CITY OF ALBUQUERQUE

February 12, 2021

Re: Karsten Court (Kraemer Fields) (M14D012I)
Architect Stamp Date: 1-21-21

Based upon the information provided in your submittal received on 2-10-2021, the above referenced plan cannot be approved for a construction permit until the following comments are addressed:

AS-1.0

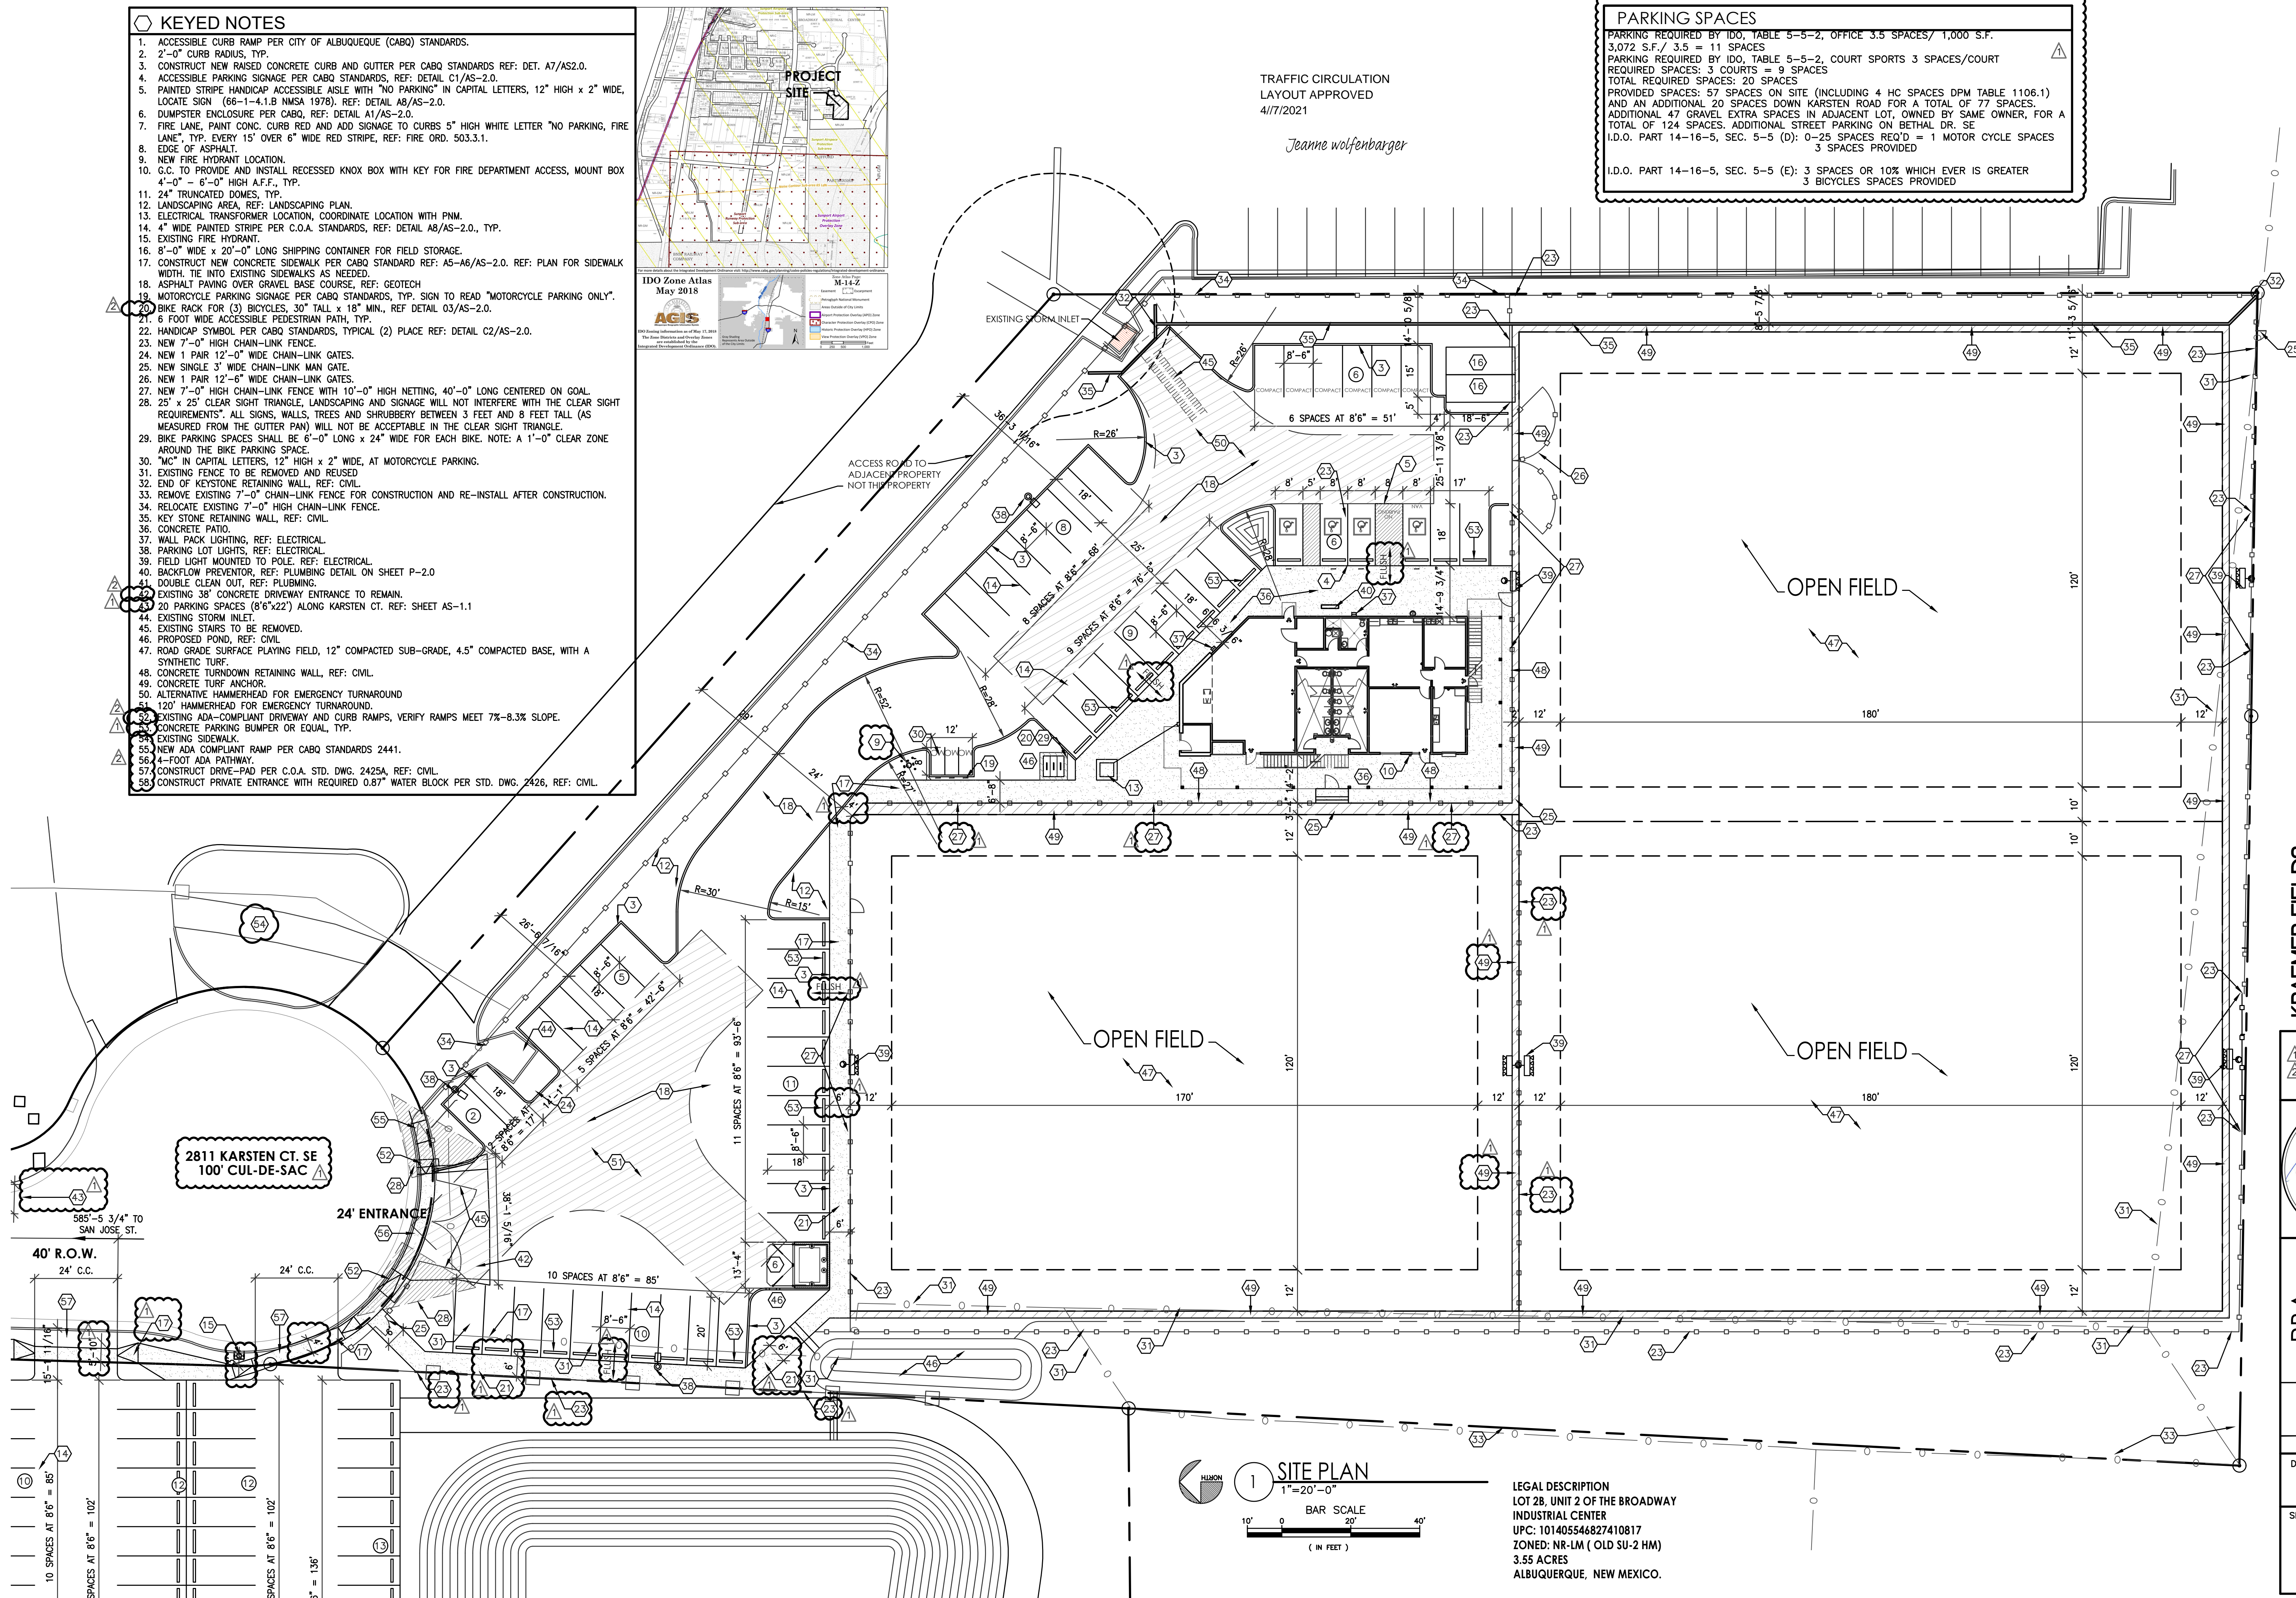
1. Provide a 6-foot wide ADA path to the public right-of-way from the on-site building. (Label sidewalk width along southern part of the property, and attempt to get a minimum 4-foot wide pathway at the northwest corner of the turf area where there is a pinch point. Include any additional curb ramps as needed.)

2. The current cul-de-sac diameter appears to be almost 100 feet and thereby is sufficient for a truck turn-around. Double-check the labeling of the right-of-way at the cul-de-sac.

6. Show 5-foot sidewalk within the Karsten Court right-of-way, and provide ADA-compliant driveway details for the new accessways off of Karsten Court. Demonstrate that a minimum of 4-foot wide sidewalk can be provided around any obstacles such as the fire hydrant. Label tie-ins to existing sidewalk. Ensure sufficient right-of-way for the sidewalk.

7. Indicate 2% maximum cross-slope on the sidewalk detail.
8. Graphically show curb ramps on the Traffic Circulation Layout. On the curb ramp detail provided for the van accessible aisle, indicate width of ramp and a maximum 1:12 slope. (Be sure to include ramp details that match the condition for the ramp on the site plan drawing, and reference the ramp drawing that will be used within the keyed notes.)

9. For the gravel parking lot, provide all necessary dimensioning for the aisles and parking spaces. Provide parking bumpers to delineate the parking spaces. Clearly show all accessways and accessway widths.
